I-2513 B & D 4B Meeting Minutes

I-2513B&D Concurrence Point 4B Meeting

Date: June 18, 2025
Location: CCA Structures Conference Room
Time: 1:00PM
Attendees: Hannah Headrick – NCDOT
John Jamison – NCDOT (Teams)
Todd Lapham – NCDOT
Carlos Sharpless – NCDOT (Teams)
Yates Allen – NCDOT (Teams)
Jennifer Parish – NCDOT (Teams)
Daniell Bagley – NCDOT (Teams)
Scott Jones – USACE (Teams)
Lori Beckwith – USACE (Teams)
Holland Youngman – FWS (Teams)
David Moyar – JV (Teams)
Byron Holden – RK&K
Jeremy Keene – RK&K
Pete Stafford – RK&K (Teams)
Chris Rivenbark – RK&K
Vidya Mohandas – WSP
Kase Schalois – WSP
Chris Lewis – TGS (Teams)

The Hydraulic Review was held in order to reach compliance on Merger Concurrence Point 4B, further known in the minutes as 4B, for I-2513B&D, I-26 / I-240 in Buncombe County. The following items were discussed and conclusions reached:

| PERMIT DRAWING SHEET 8 OF 81 | |

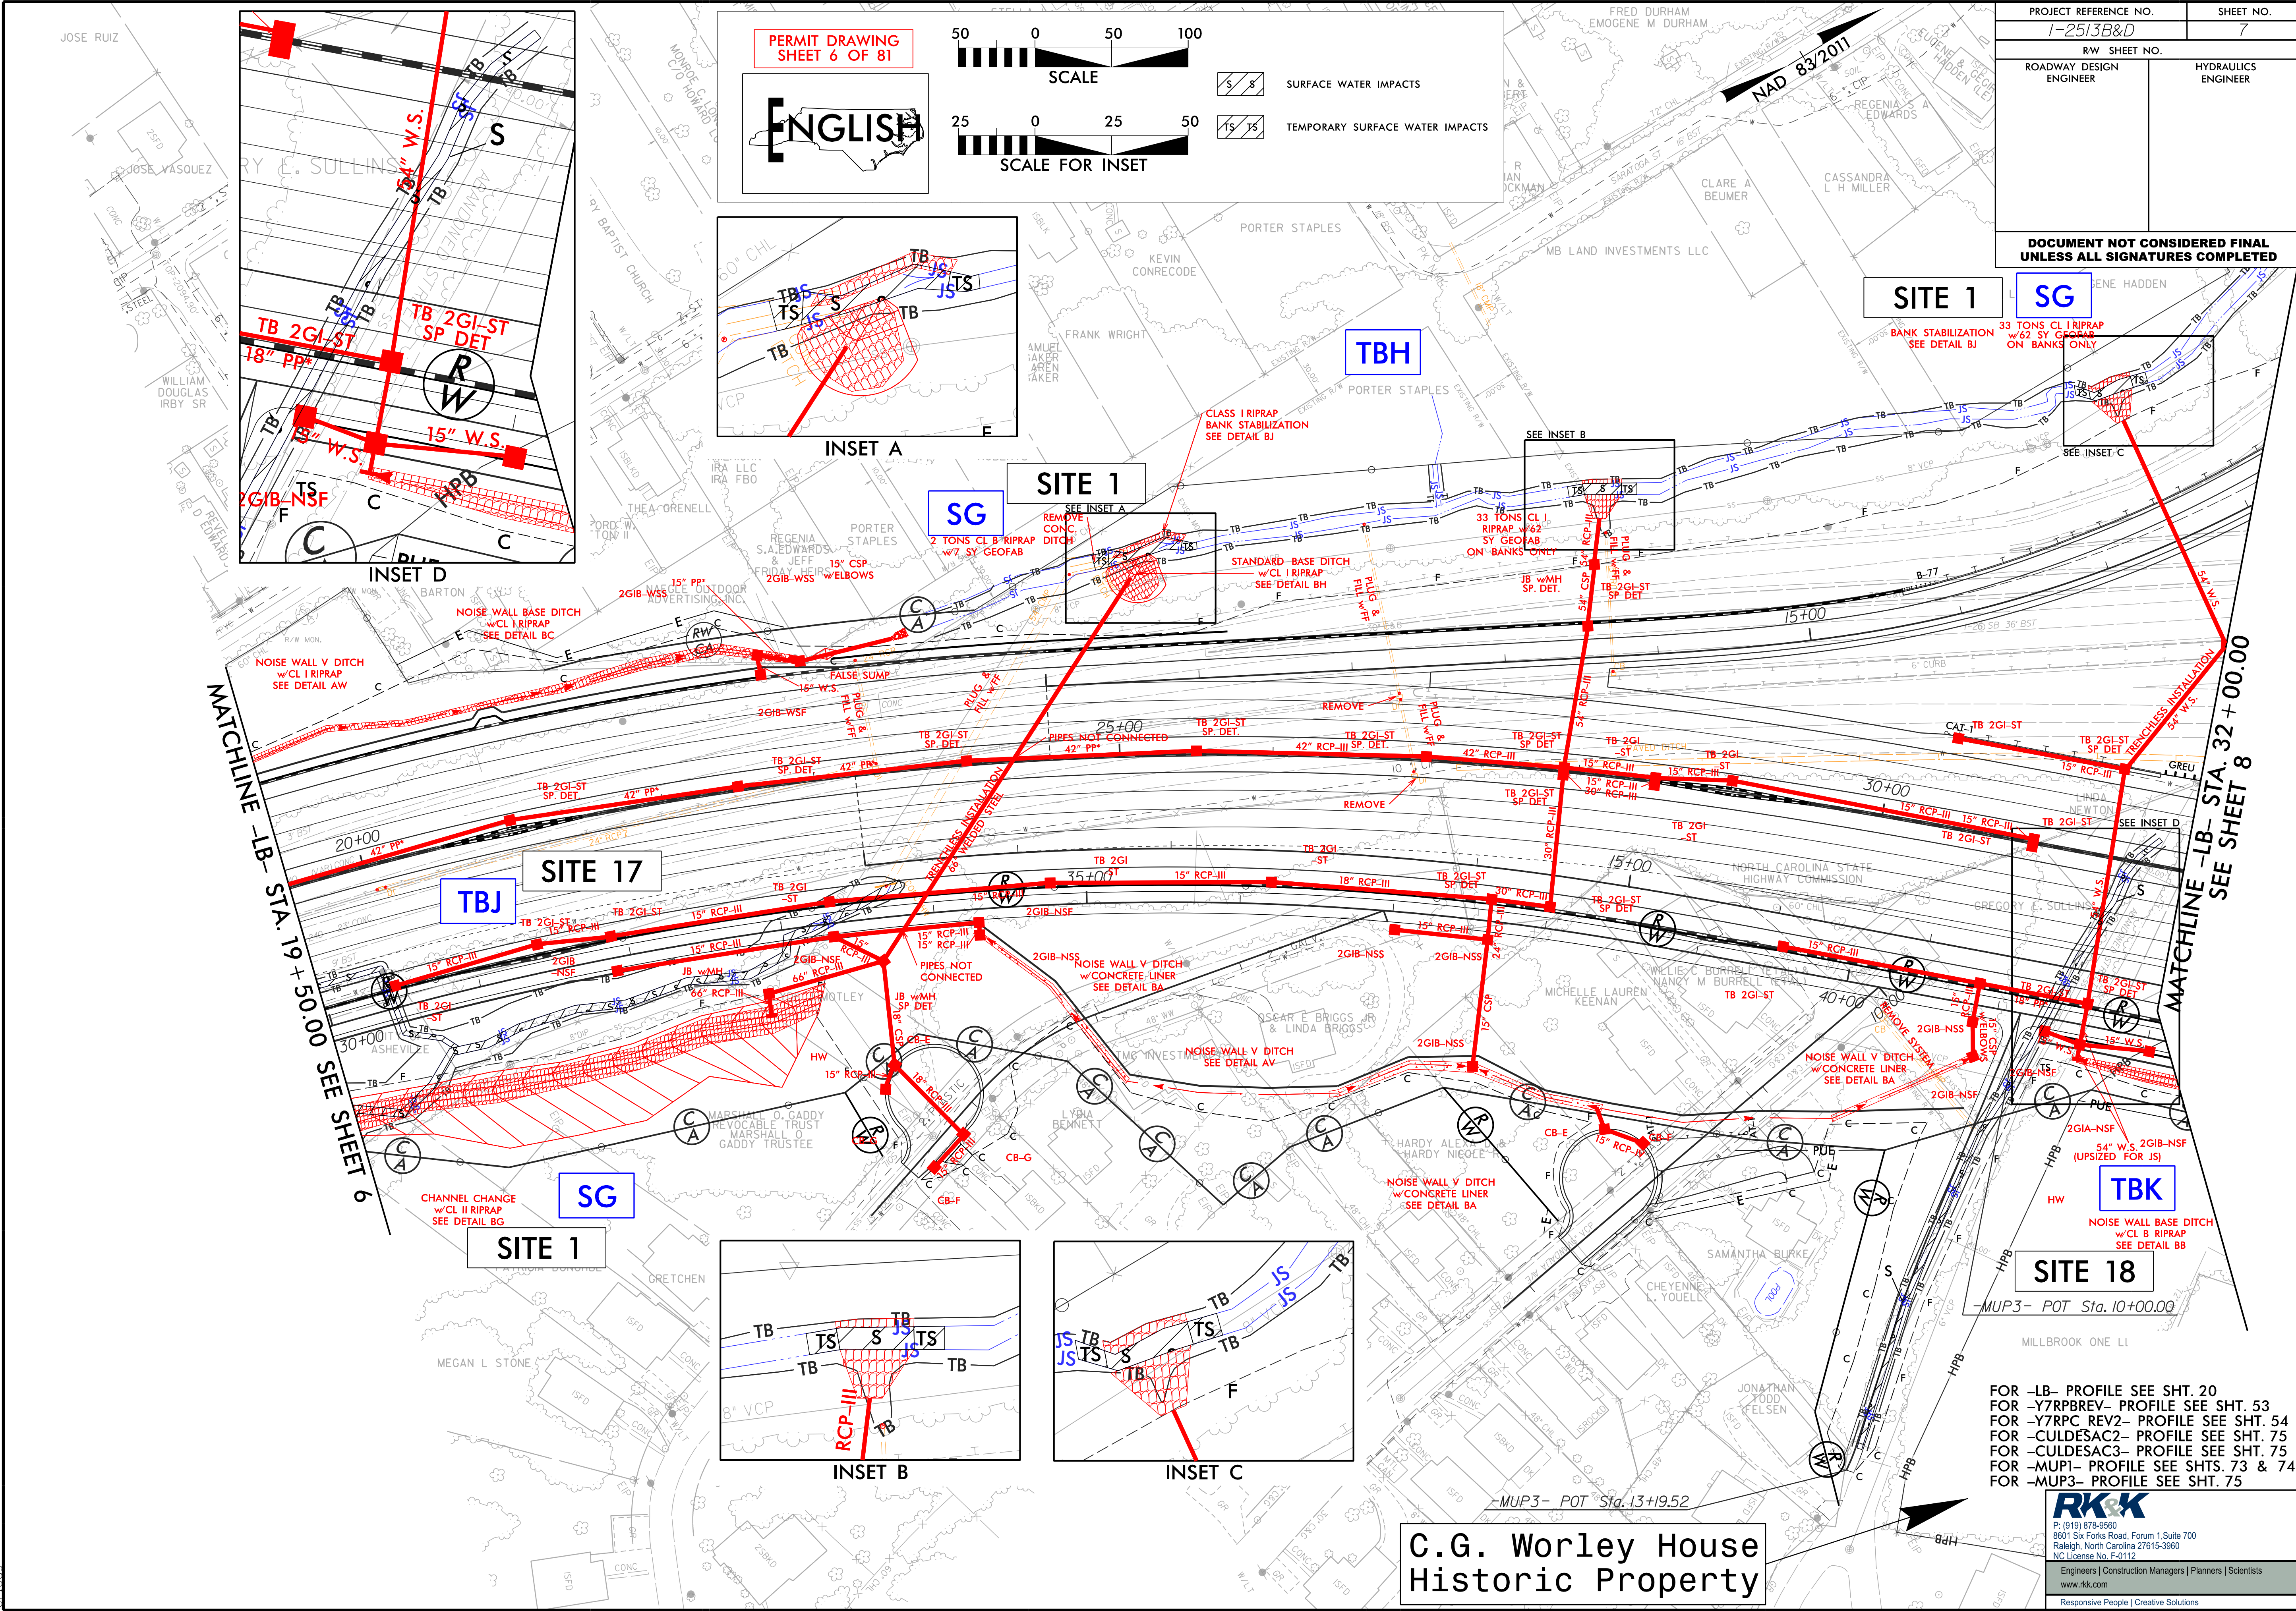
- Tributary TBI and stream SG (right side) continue on to sheet 7.
- Stream SG was carried under I-26 by an existing 54" CMP. The proposed design is now carrying SG under I-26 in a 72" WS pipe that has been buried 1' due to it being jurisdictional.

- Mr. Cook asked if burying this pipe would be required since the pipe slope is greater than 3% and the pipe is 335' in length.
 - Dave McHenry did not see an issue with it not being buried since headcutting wouldn't be an issue due to the riprap lined channel.

- Lori Beckwith and Amy Annino agreed that it did not need to be buried.
- Stream SG (Permit Site 1) continues on the left side of the roadway.
 - There will be various spots with impacts along the left side at the outlets of pipes where bank stabilization has been added. At these locations, bank stabilization will be taken down to the channel bed elevation but will have no riprap in the channel.

- It was noted that some of these outlet points will be revised to better align with existing swales/discharge points. Additionally, drop structures may be used/added, to minimize the velocities at the outfalls.

- There is a sanitary sewer line adjacent to stream SG, and RK&K is coordinating with the utility design team to determine if there are any conflicts and work on resolutions if conflicts are found.
